#### Q1.1.9 Planning Benefits

##### Q13.1.6 Sustainable Drainage

Drawing Title:
Works Plans
Great North Road Solar and Biodiversity Park
Key Plan

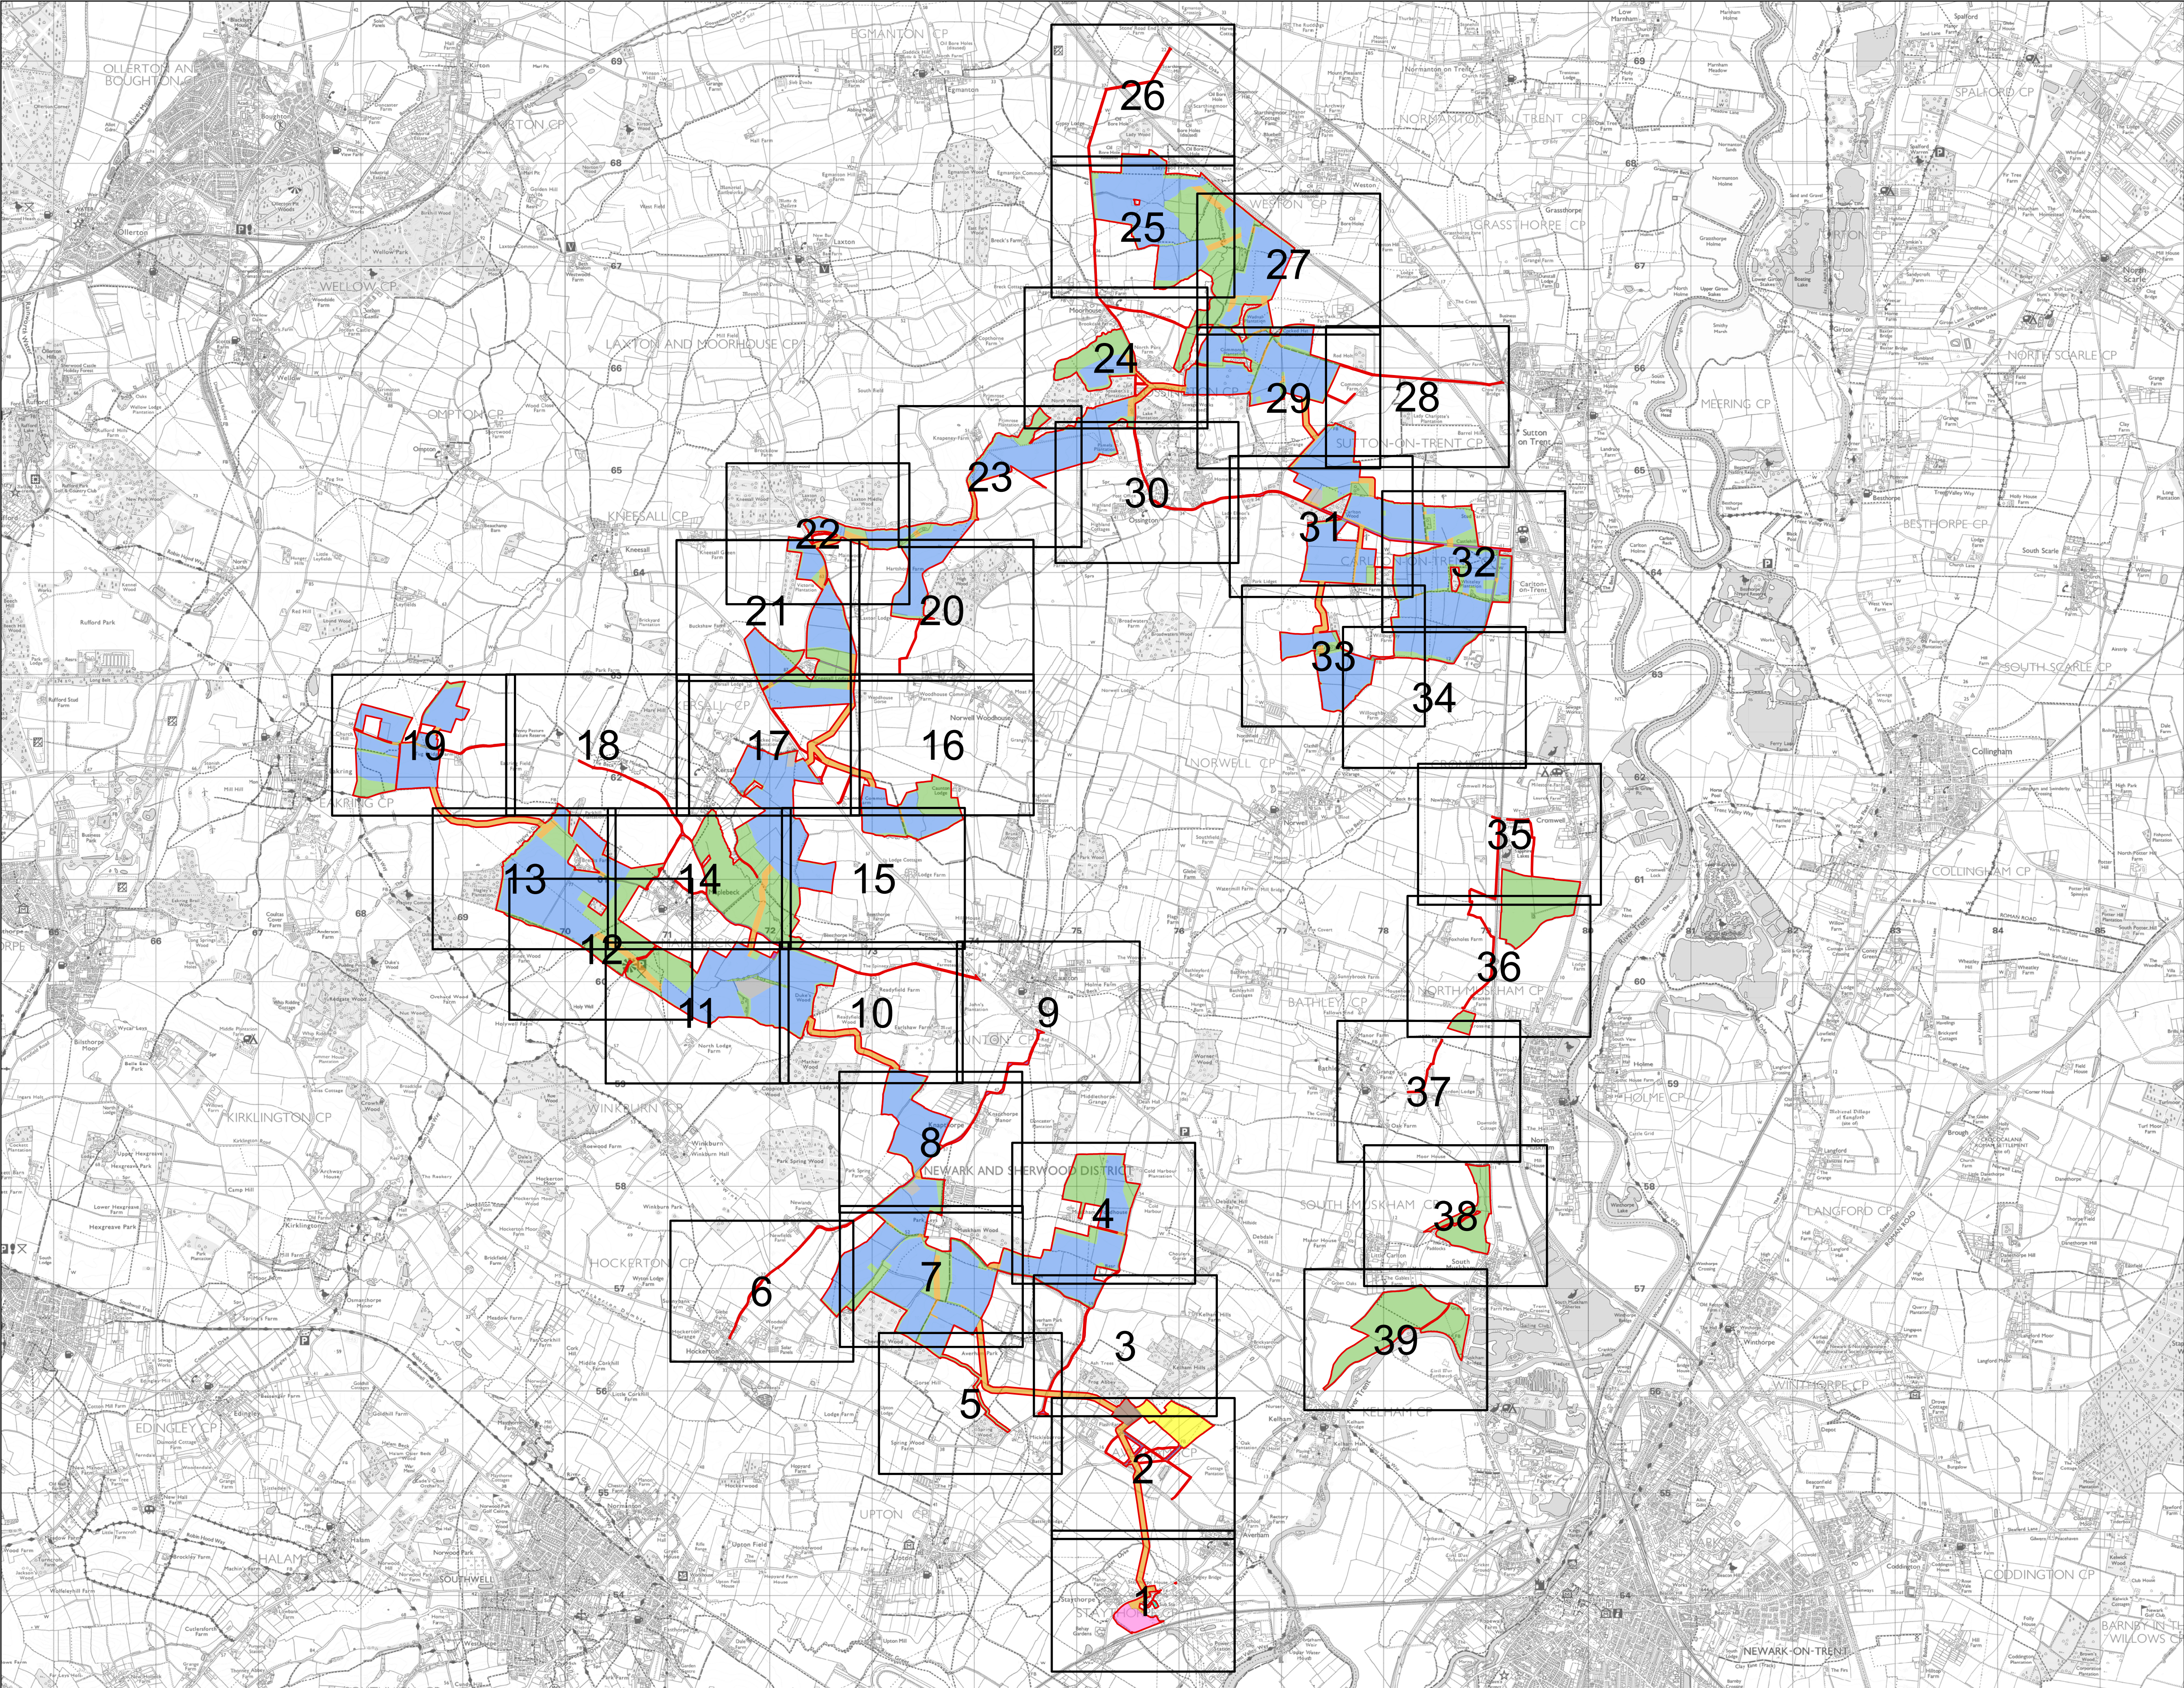
The application does not appear to include a comprehensive sustainable drainage strategy covering all stages of the works. In particular, no clear provision is evident for:

- Work No. 2 – Underground cables
- Work No. 3 – Mitigation and enhancement
- Work No. 6 – Modifications at the existing National Grid substation
- Work No. 7 – Modifications at Staythorpe BESS
- Work No. 8 – Access improvements

This omission should be addressed.
